From: Dan Young
Sent: Wednesday, April 10, 2024 10:07 AM
To: Bradley Gasawski
Subject: RE: RU-24-00001 Horish - Notice of Application

CDS is requesting comment on the following **reasonable use** application: **RU-24-00001 Horish**. Links to the file materials can be found below. The comment period will end **April 17, 2024, at 5pm**. CDS will assume your agency does not wish to provide comment if not received by this date. Please let me know if you have any issues accessing the materials.

### Proposed Access Driveway

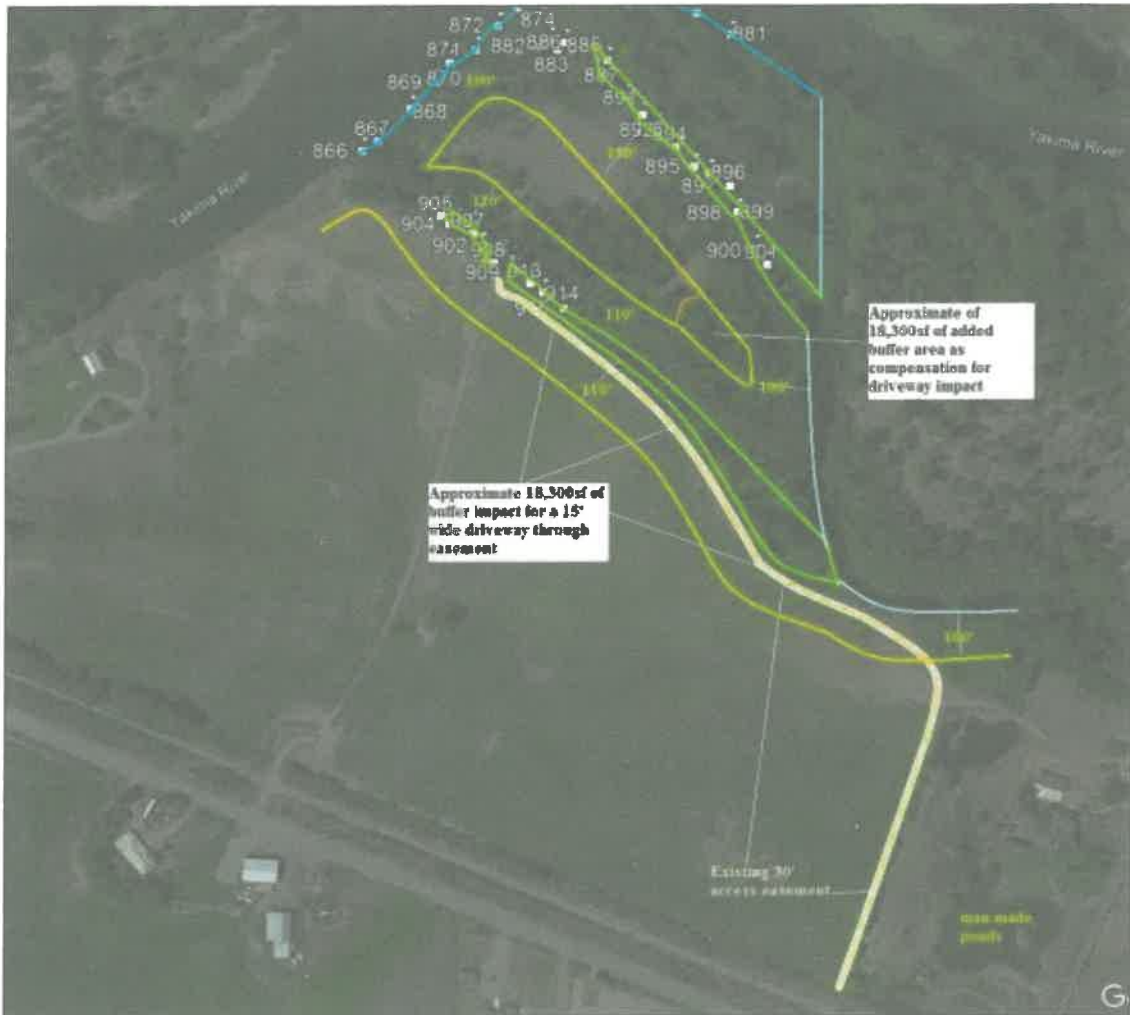
Driveway to meet the requirements of the International Fire Code (IFC) including Appendix D.
